The El Paso County Conservation District has reviewed this project and we have the following concerns:

ANTLER RANGE FILING NO. 1
 INITIAL-FINAL GEC PLAN

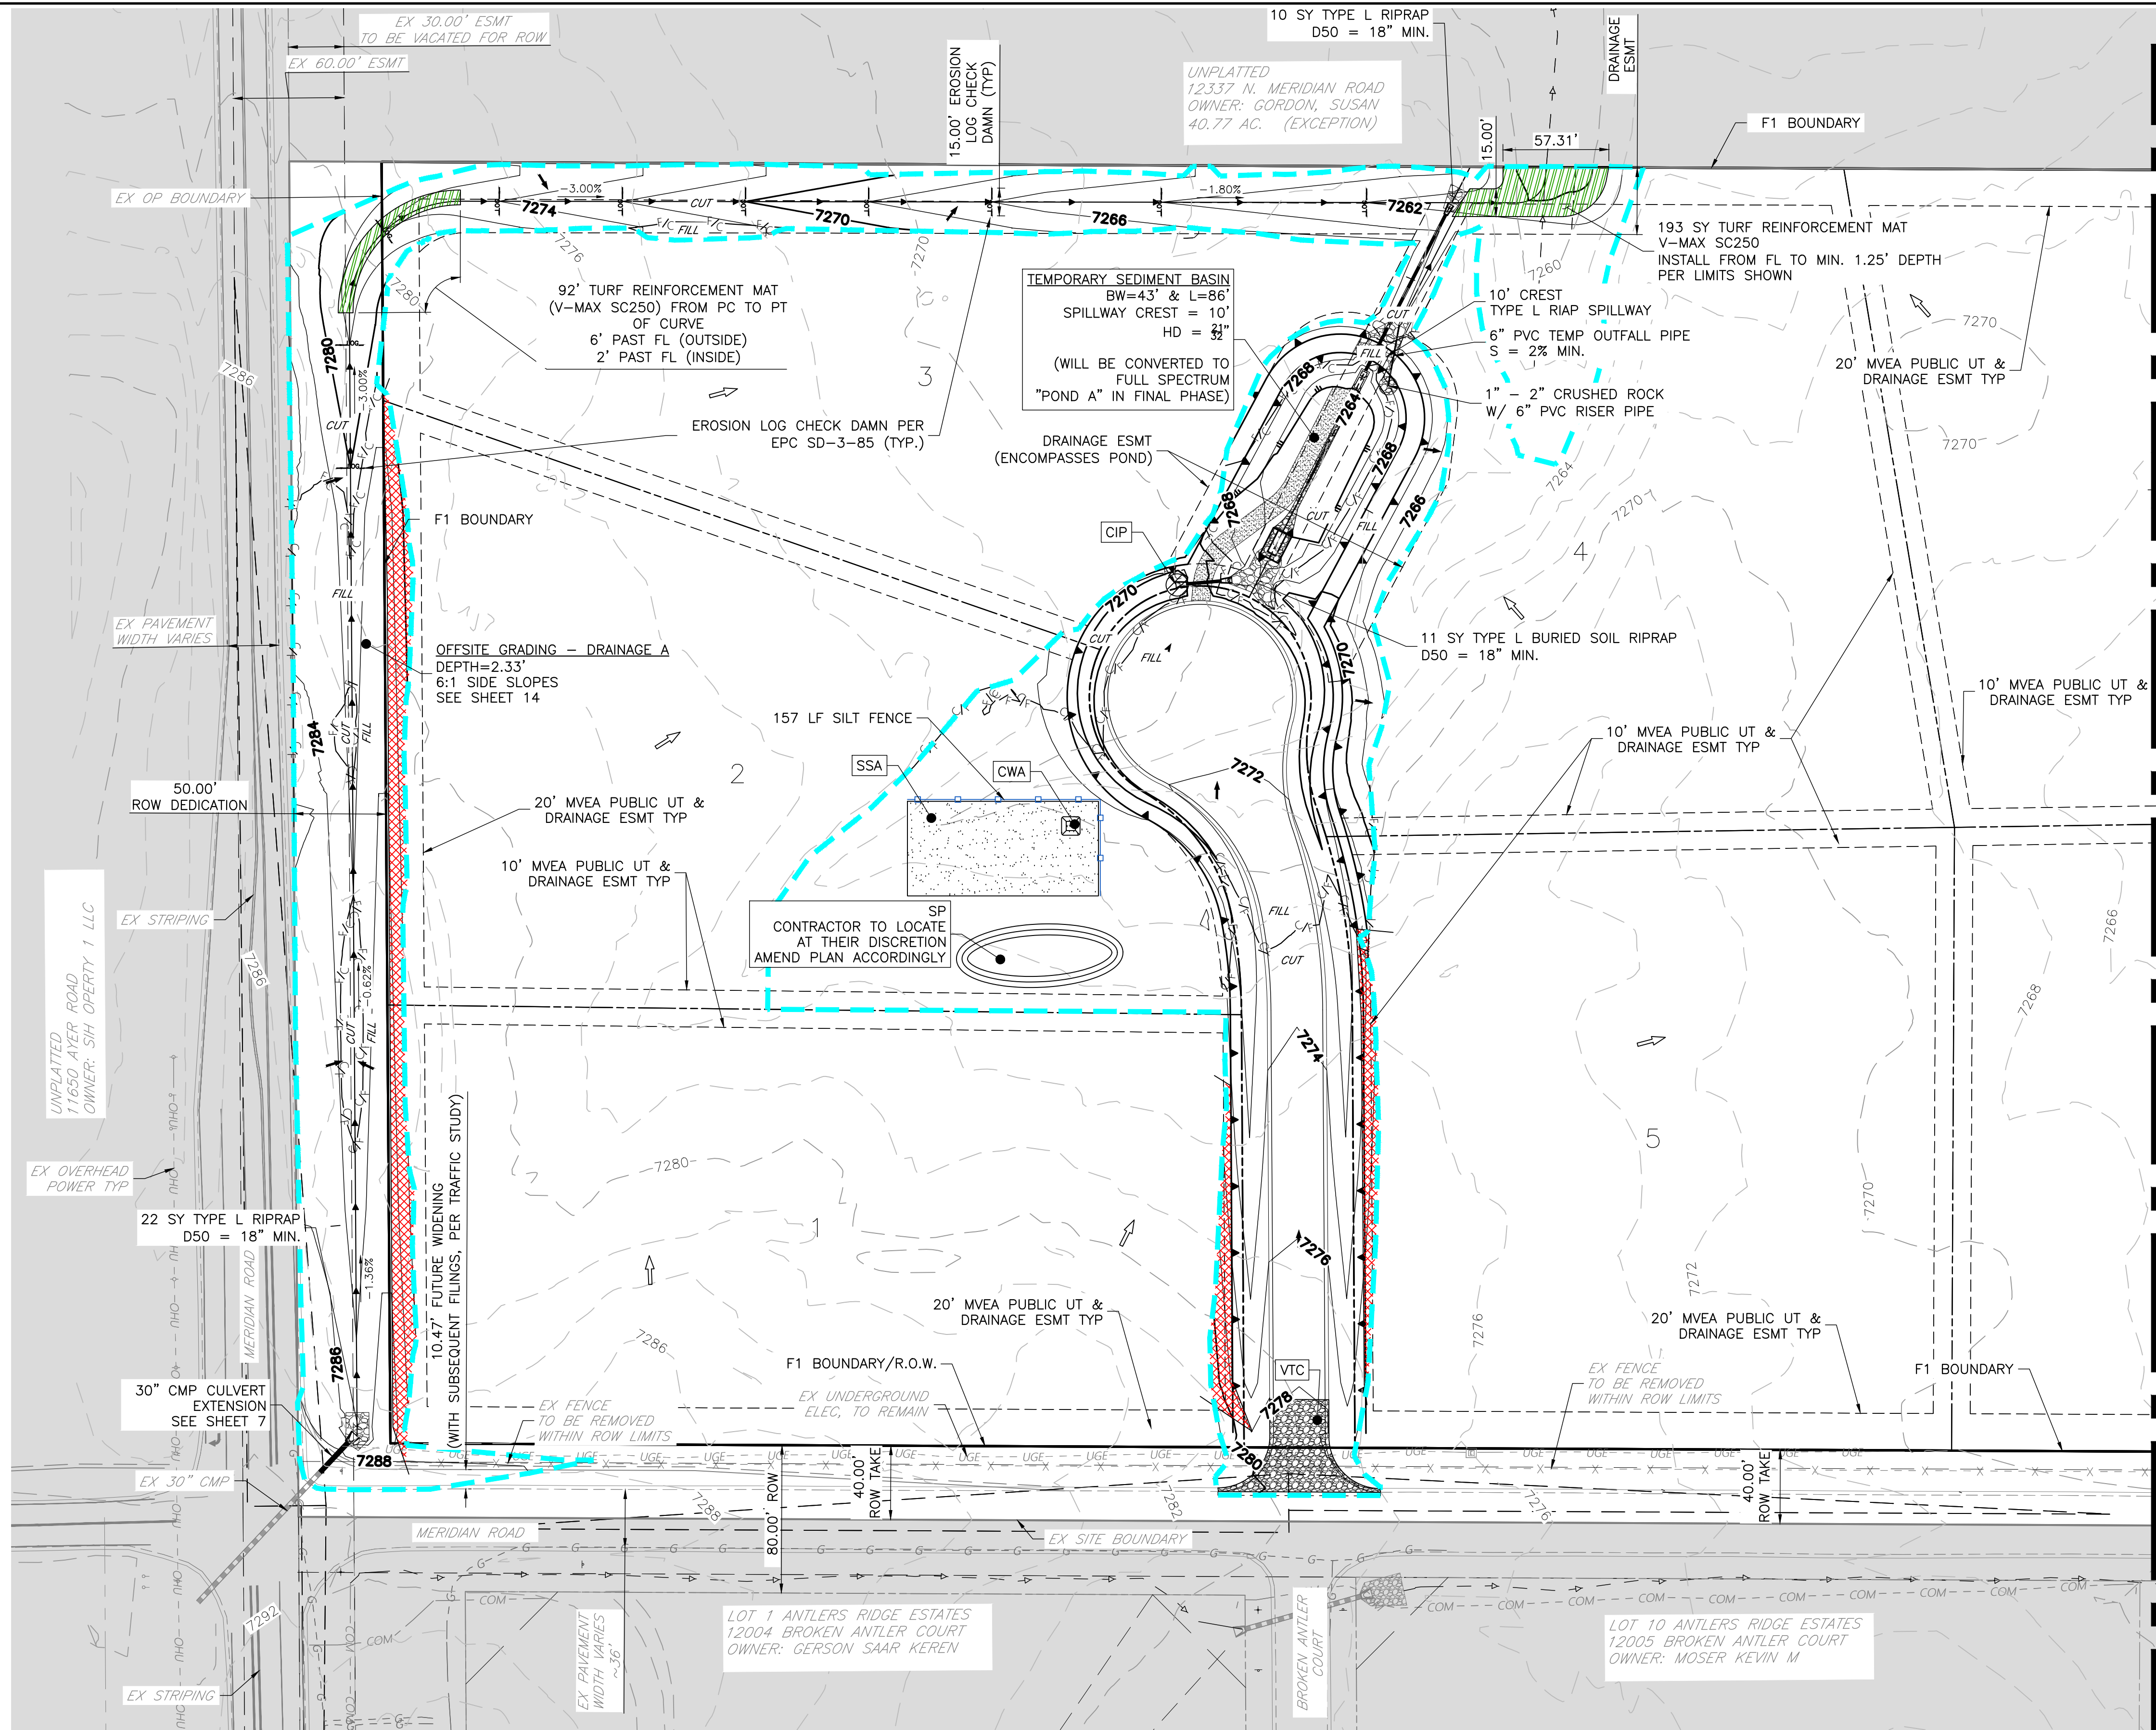
Based on the map and proposed lots, there is a minor drainage that runs across the area that eventually runs into the nearby Black Squirrel Creek. This creek had shown severe erosion issues due to flooding in recent years and we would like to see that this is protected from additional runoff/surface erosion during construction. So we would like to see an erosion control measure that prevents this as much as possible that will be required for when these lots become built on that prevents this for both during and following construction.

A) Prior to any dirt work, appropriate dirt erosion measures such as silt fences should be installed to catch any dirt that may erode off the side during the construction period.

B) Topsoil of disturbed soils stripped to a depth of approximately 6 inches and stockpiled separately, with stockpile side slopes no steeper than 3:1 to prevent erosion issues during construction. This topsoil should then be redistributed evenly on graded areas around the constructed building and prior to seeding to ensure the best chance for germination success.

C) Disturbed areas be mulched and revegetated within 45 days of disturbance using either: plant/grass species native and/or naturalized to El Paso County, or water wise landscaping with mulches that help protect the soil. Lawn areas should be treated with 1" compost prior to seeding or sod installation to help with reducing water needs.

D) Disturbed areas that are not to be landscaped should be either: mulched after seeding with weed-free hay or straw mulch at approximately 5,000 lbs per acre; Or areas that are not suitable for revegetation such as driveways, parking areas, and safety areas around the building should have a 1-2" layer of crushed rock, road base, or gravel to assist in preventing having exposed soil that would be prone to wind/runoff erosion concerns (unless being paved).

Response: The owner and developer understands. This is the reason why they are not proposing any disturbance in this area and have placed it in a no-build area.

Response to items A-D: All future builders will be required to follow the rules and regulations that are already put in place. In most instances a BESQCP will be required.
